Application No: M/91/21/PL
Site Address: 27 Central Drive Middleton-On-Sea PO22 7TT
Description of works: Variation of condition 2-approved plans & removal of condition 4-materials included on plans imposed under M/25/19/PL.

Thank you for your internet representation made on 2nd August 2021 which has been recorded as an objection with the comments as follows:

PROJECT	27 Central Drive - Elmer Beach	DATE	16/09/18
TITLE	Proposed South Elevation	DRG NO	IBA/507/05
SCALE	1 : 50	REVISIONS	B

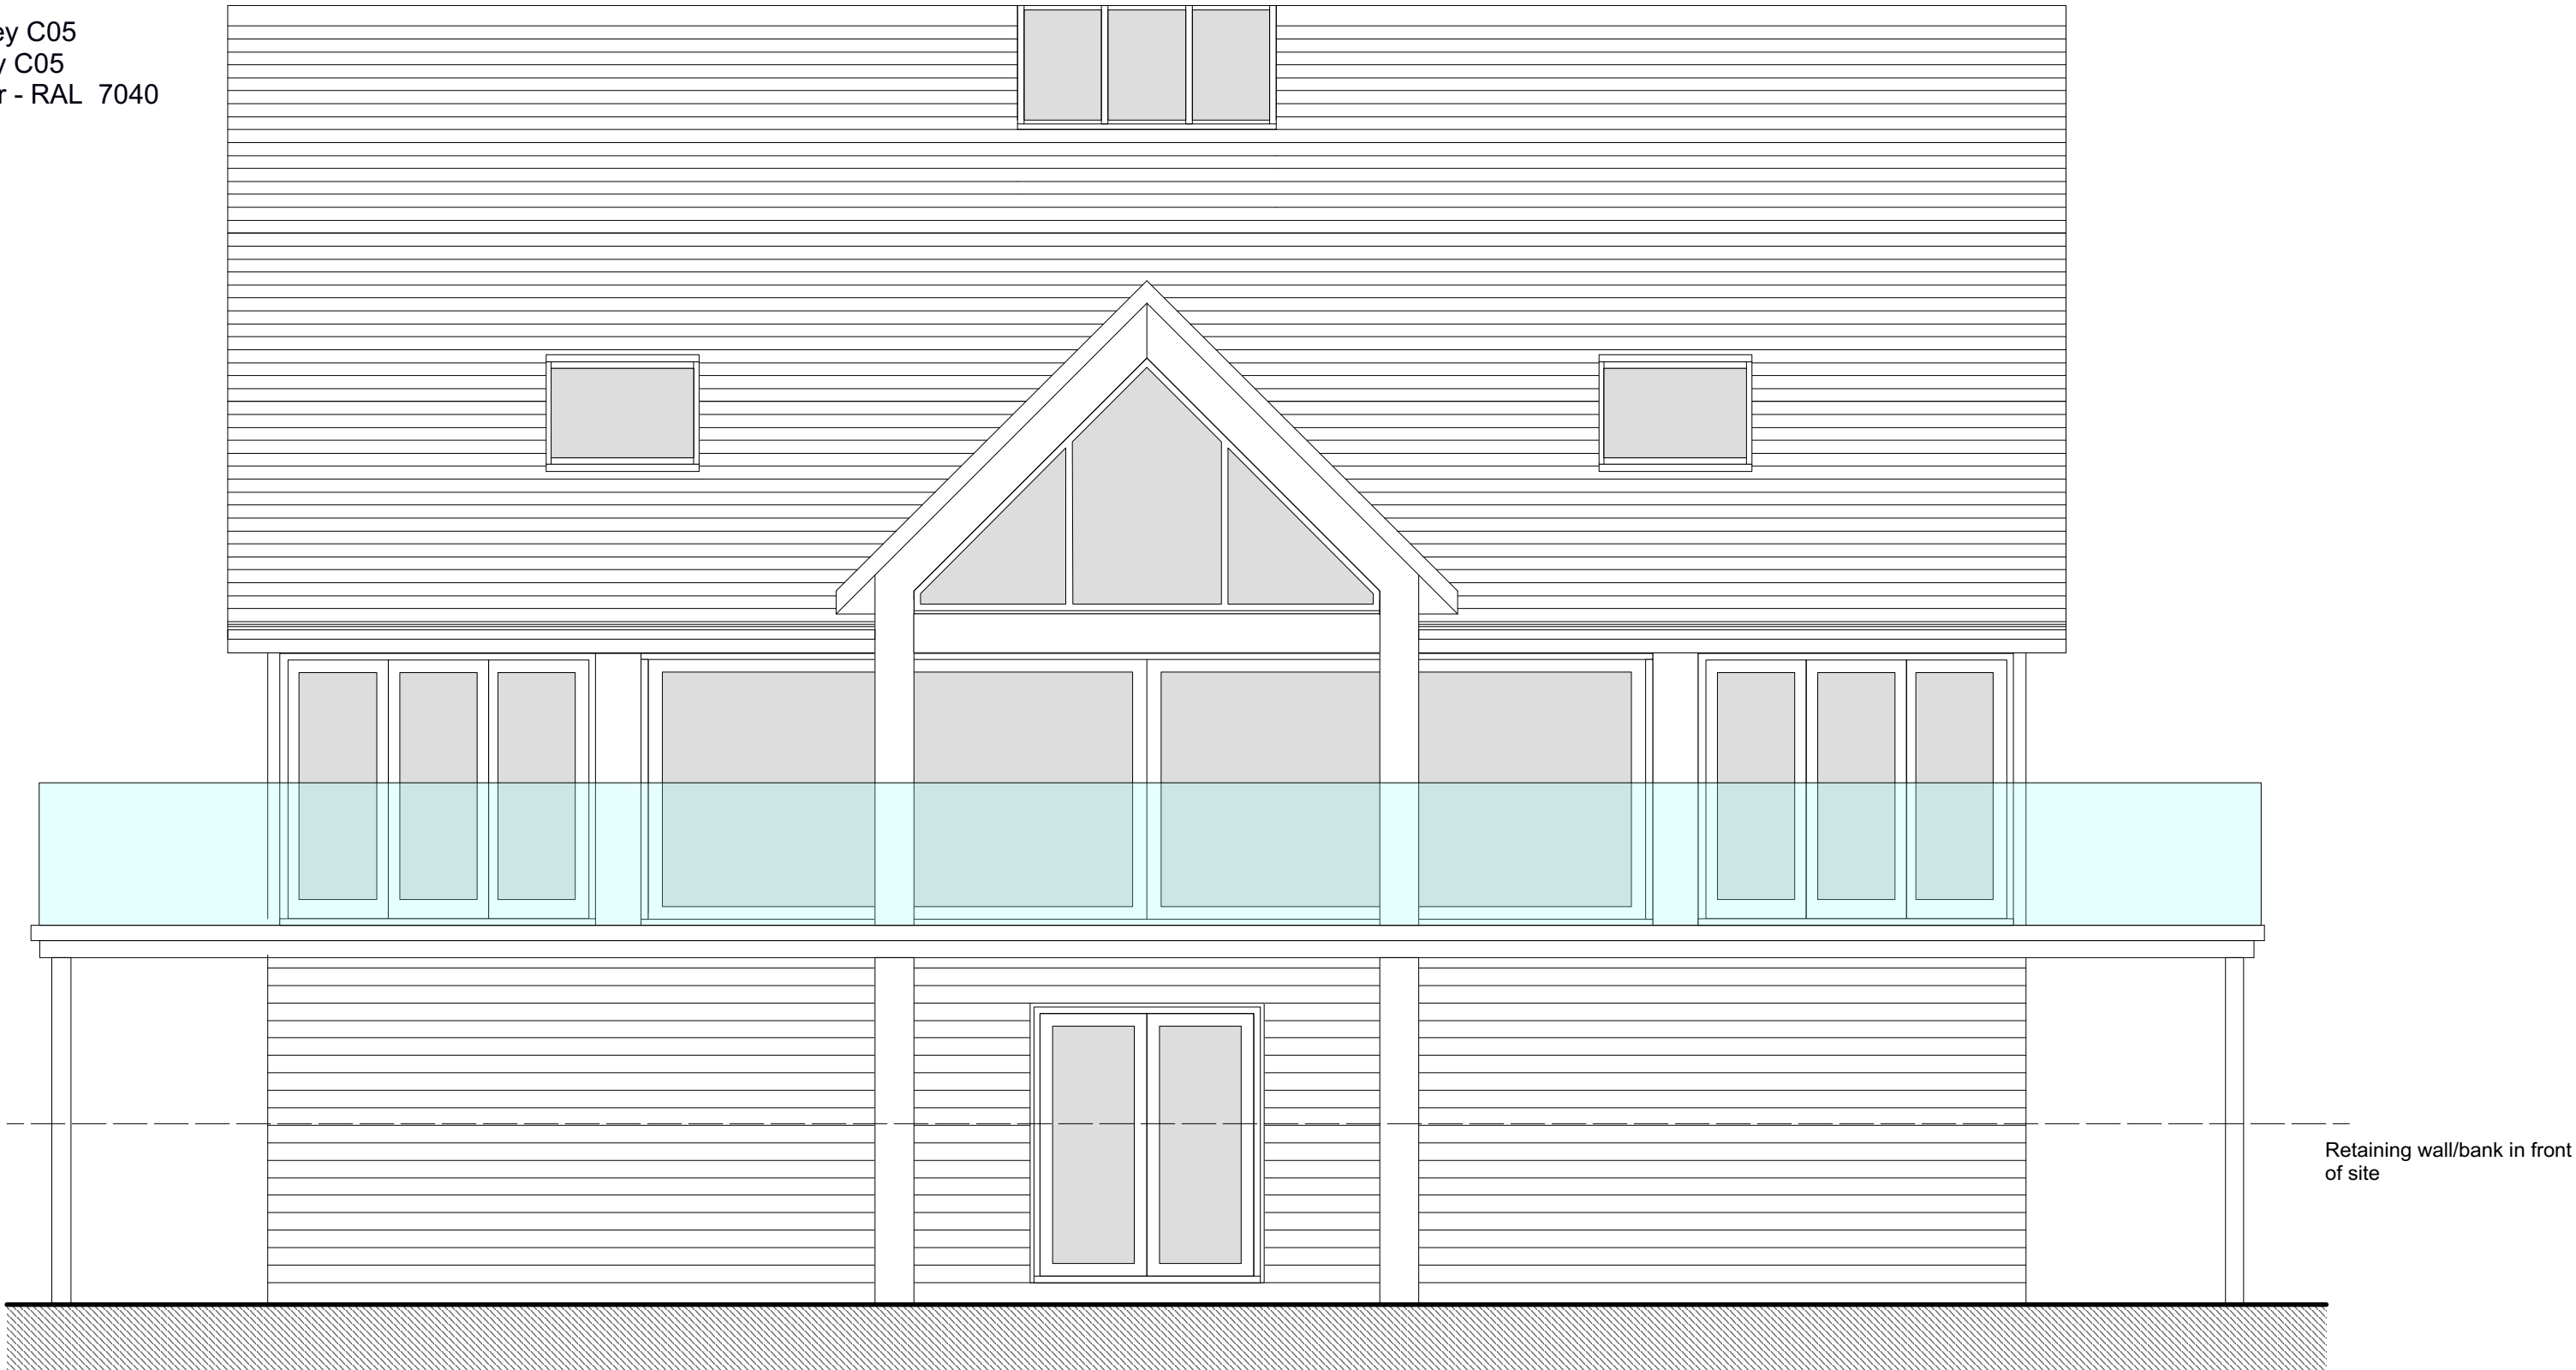
I find this proposed height and roof elevation to be excessive by comparison to the surrounding houses. The builders or owner has not stuck to the original plans and clearly have no respect for local residents. It dwarfs every other house and should be reduced to a more in keeping size. I believe there has been mentioned a lift but that is no reason for the property to be taller.
